CITY OF PORTLAND, MAINE
PLANNING BOARD

Project Name: The Forefront at Thompson's Point Project Level III Site Plan and Subdivision Application

ID: 2015-133 & 2015-159

PLANNING BOARD REPORT PORTLAND, MAINE

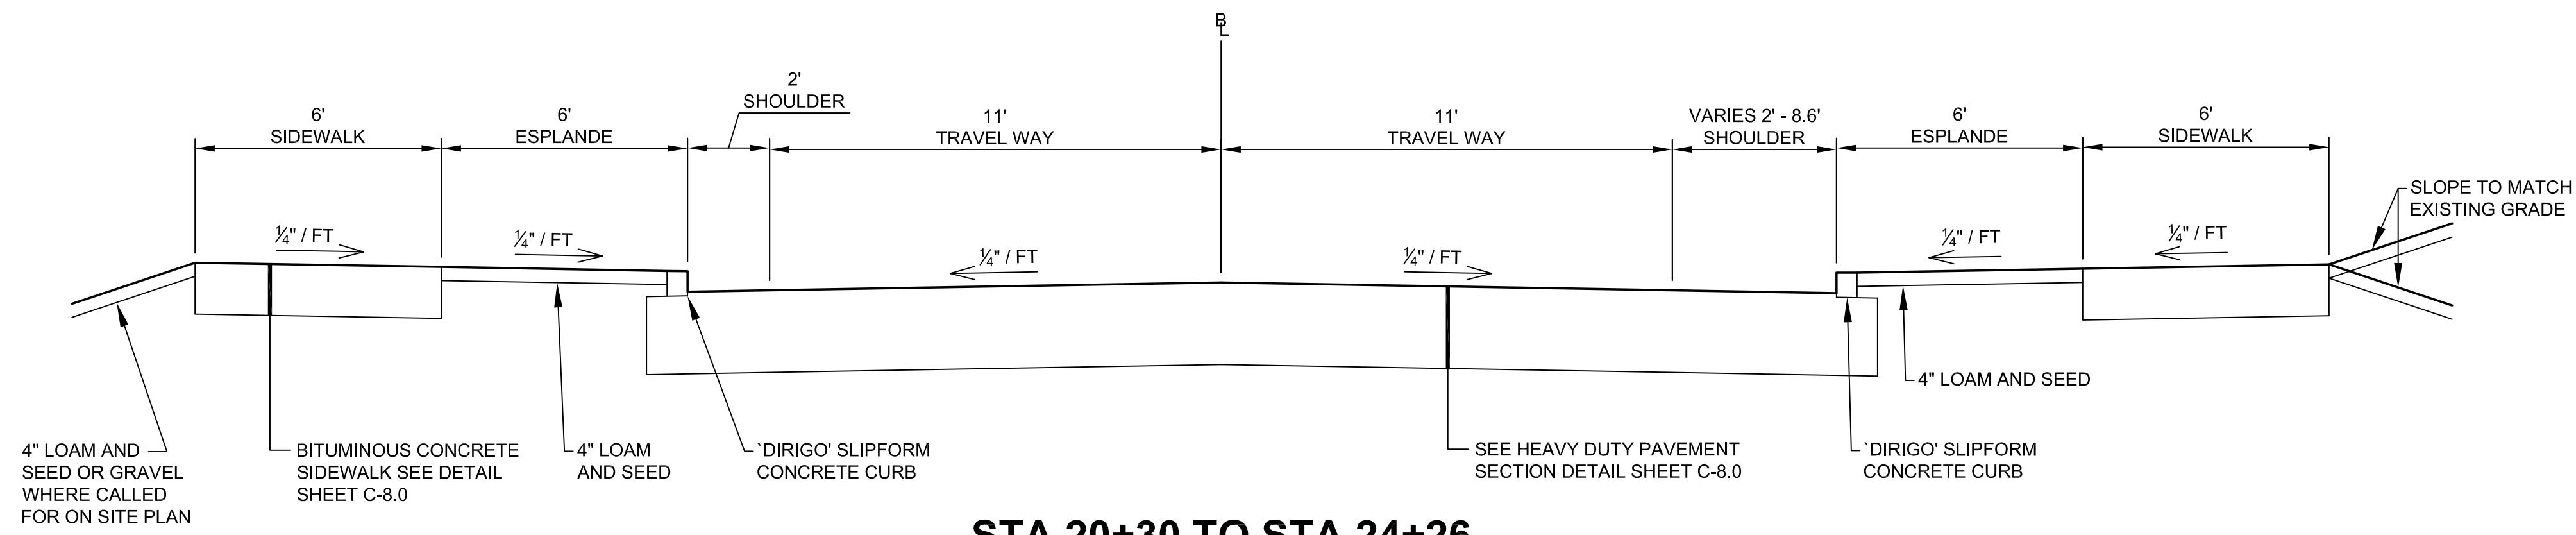
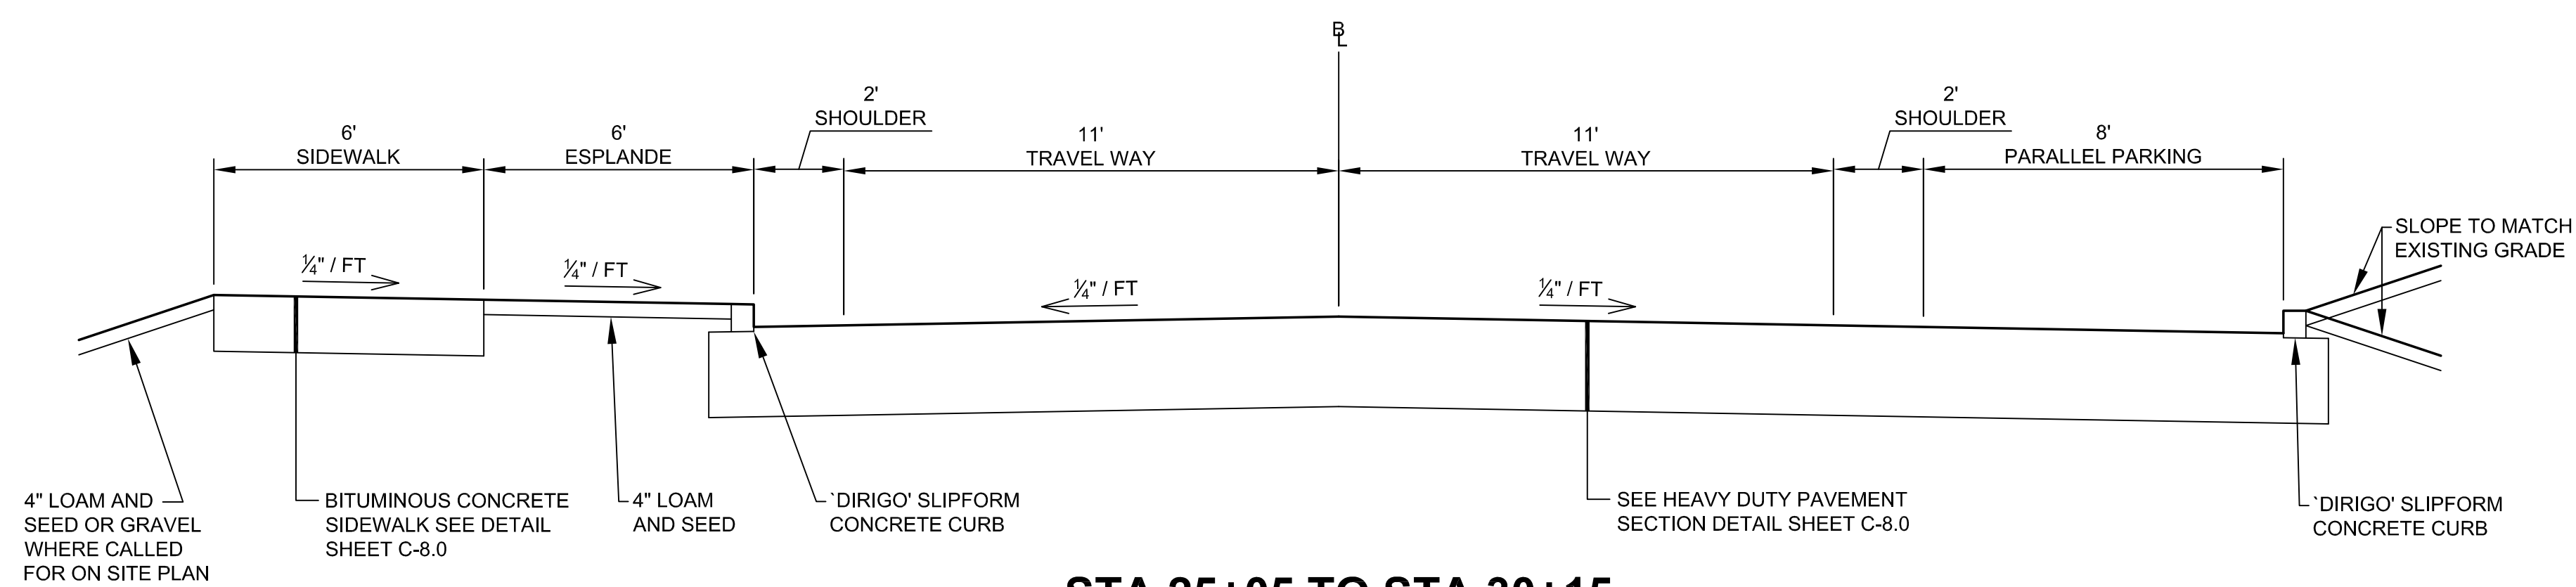
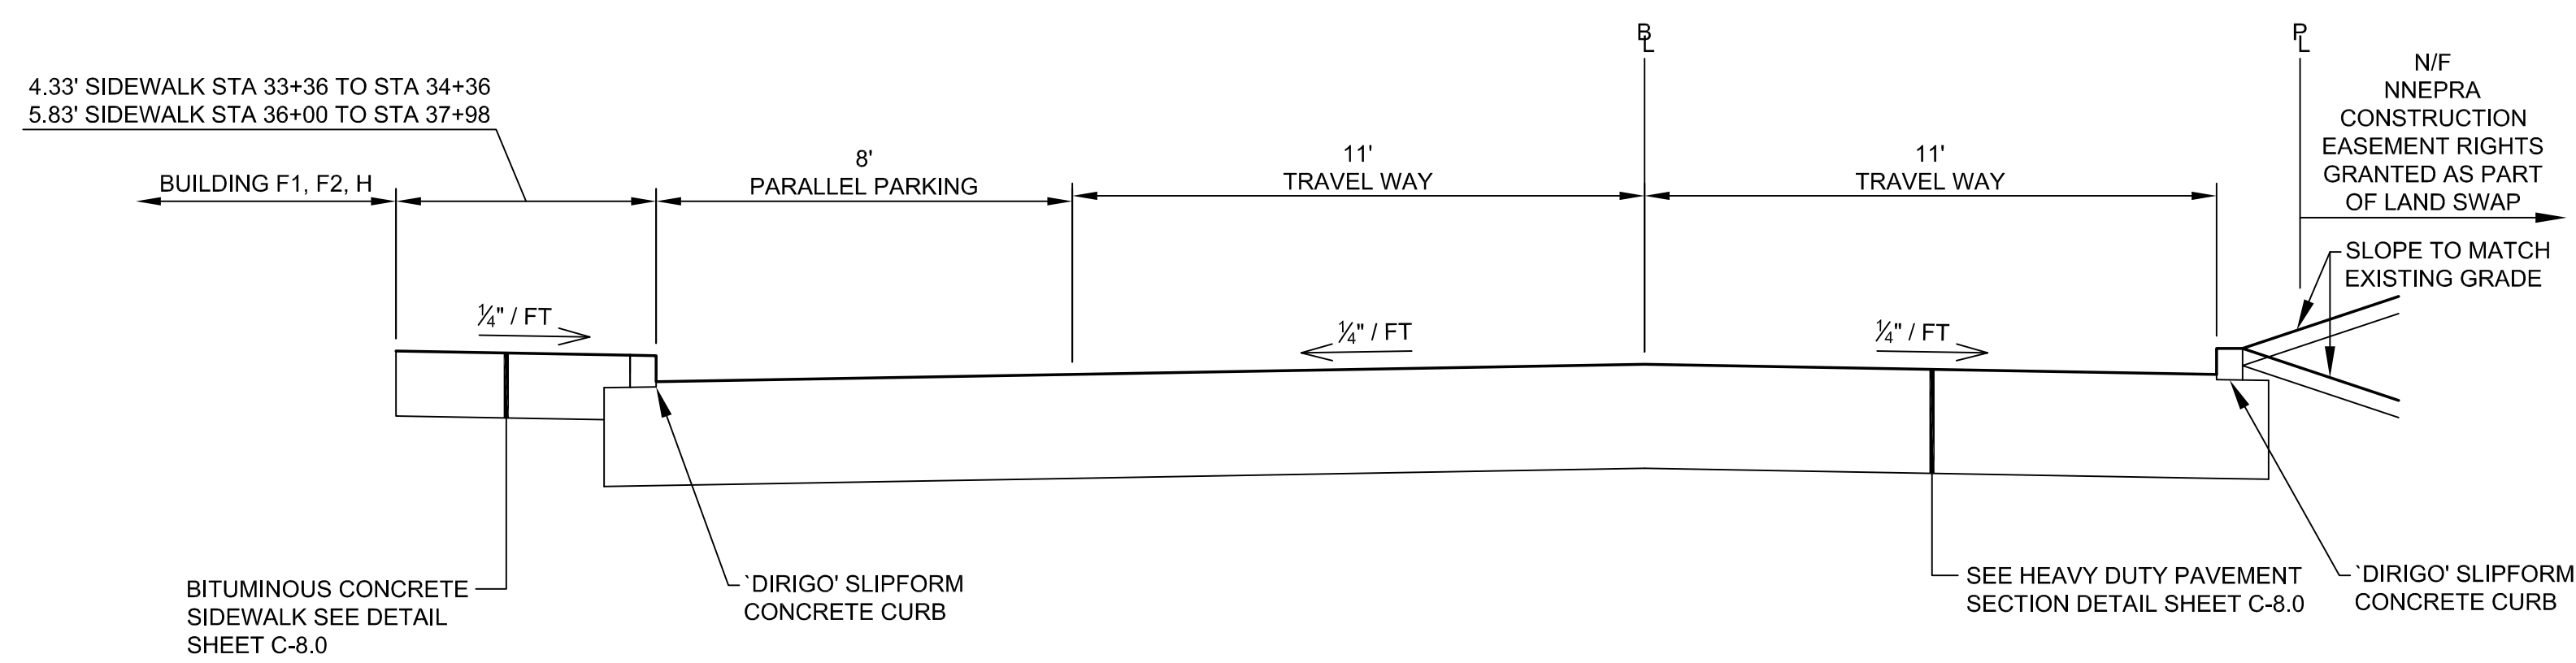
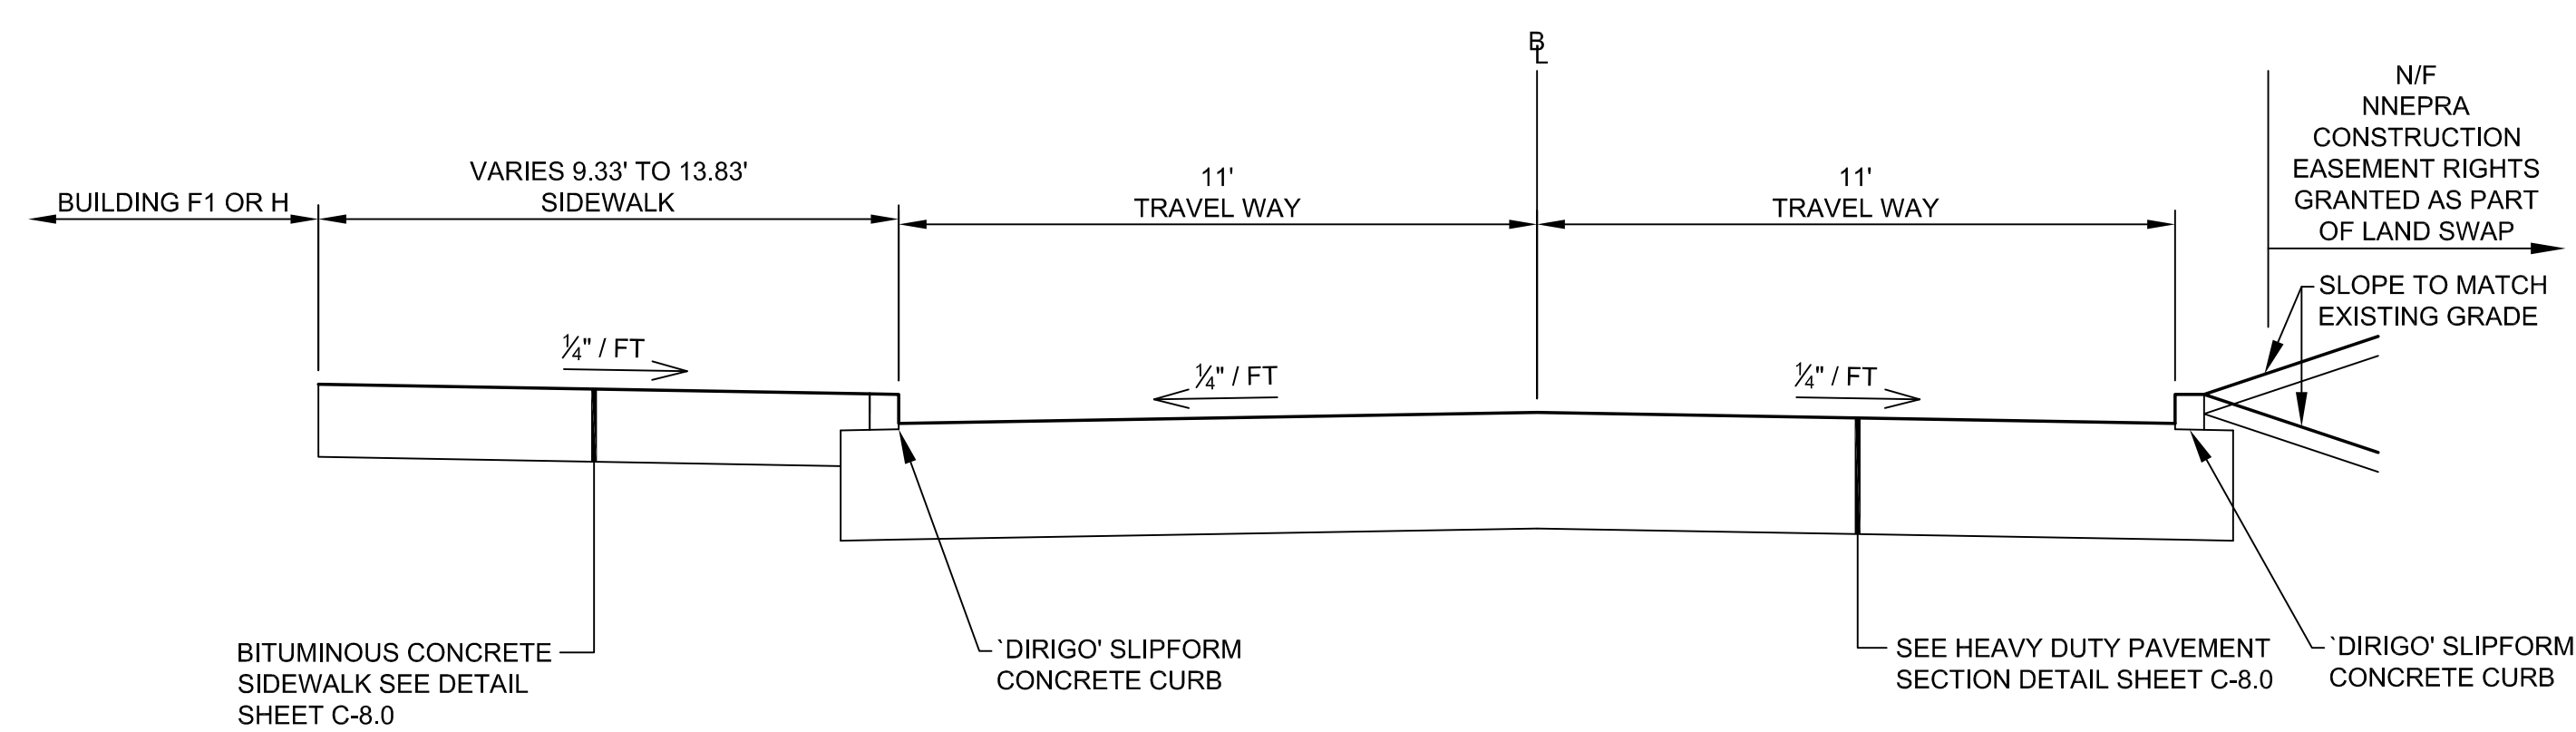
3. 10.8, requiring a minimum aggregate base course thickness of 3 inches for collector roads, to allow for alternative road design specifications as noted on Sheet C7-0. .

5. Figure I-2 (Collector Street Cross-Section), requiring a minimum roadway width of 40 feet for collector roads, to allow for a variable width of 30-39 feet.

6. Figure I-2 (Collector Street Cross-Section), requiring a minimum esplanade width of 5 feet for collector roads, to allow for a 4ft wide esplanade.
